**From:** [Lakeman, Ethan](#)  
**To:** [Rampion2;](#) [REDACTED]  
**Subject:** MMO Response to SoS Request for Information  
**Date:** 06 December 2024 13:55:48  
**Attachments:** [06122024 EN010117 MMO Response to SoS Request for information.pdf](#)

MMO Reference: DCO/2019/00005  
Planning Inspectorate Reference: EN010117  
Identification Number: 20045232

## **Planning Act 2008, E.On Climate and Renewables UK Ltd, Proposed Rampion 2 Offshore Wind Farm Order**

### **Post-examination submission: Request for information from Secretary of State**

Figure 1: Predicted worst case and mitigated (DBBC) behavioural response impact ranges (135dB SEL_{ss} and 141dB SEL_{ss}) for spawning herring from the piling of monopile foundations

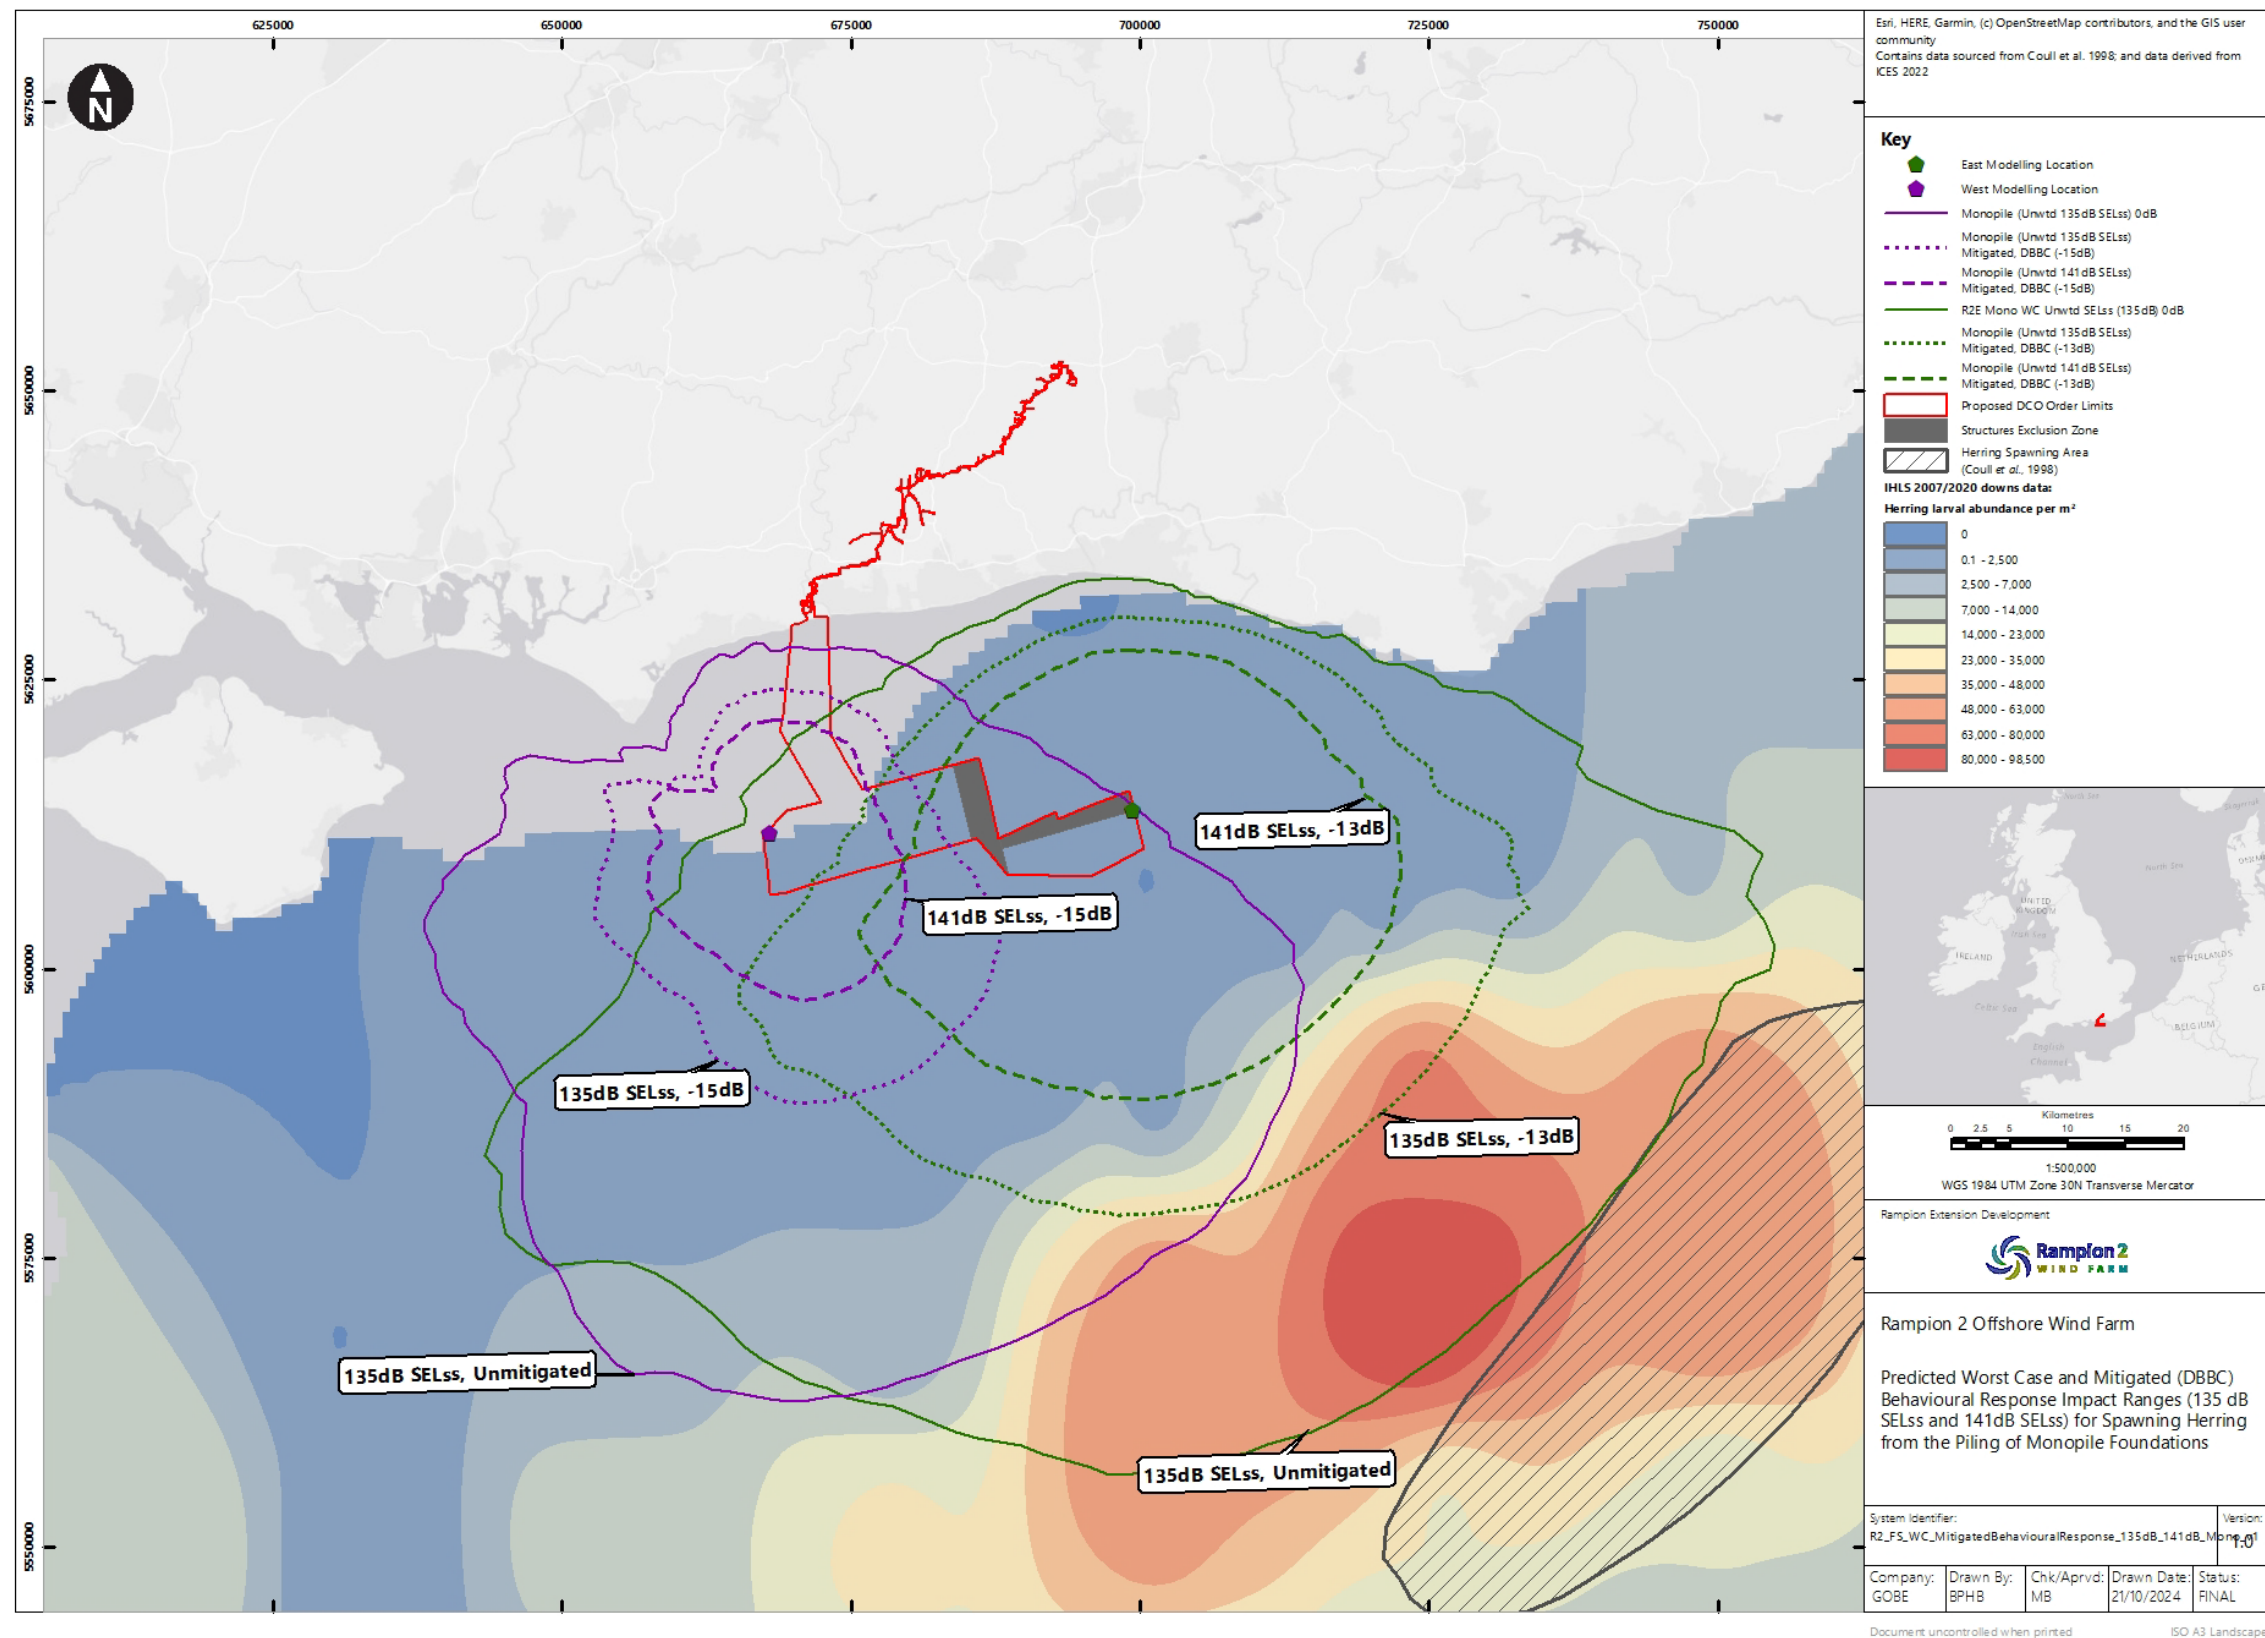
- 4.1.6 The updated modelling received via email (“Rampion 2 - Underwater noise and Herring”) and provided in Annex 1 of this Response Document show the mitigated and unmitigated noise contours for behavioural response impact ranges based on a 135 dB SELs for spawning herring from the piling of monopile foundations at the east and west modelling locations.

- 4.1.7 With regards to herring and potential disturbance to herring spawning from piling noise, the updated modelling shows that the range of impact to adult herring at their spawning grounds from underwater noise (UWN) can be reduced to an acceptable level.

- 4.1.9 In principle, now that the IHLS data used to form the aggregated larval abundance map has been clarified, and considering the updated UWN modelling as shown in Figure 1 and 2 in Annex 1, the MMO is generally content that a piling restriction during the Downs herring spawning season may not be necessary.

- 4.1.10 Whilst the MMO is content with the modelling provided, the results of the Applicant's noise monitoring at the post consent stage, particularly where foundations are installed in deeper water (>40m) locations, should be presented for review to demonstrate that a noise reduction of at least 13 dB can be achieved before this restriction can formally be removed.
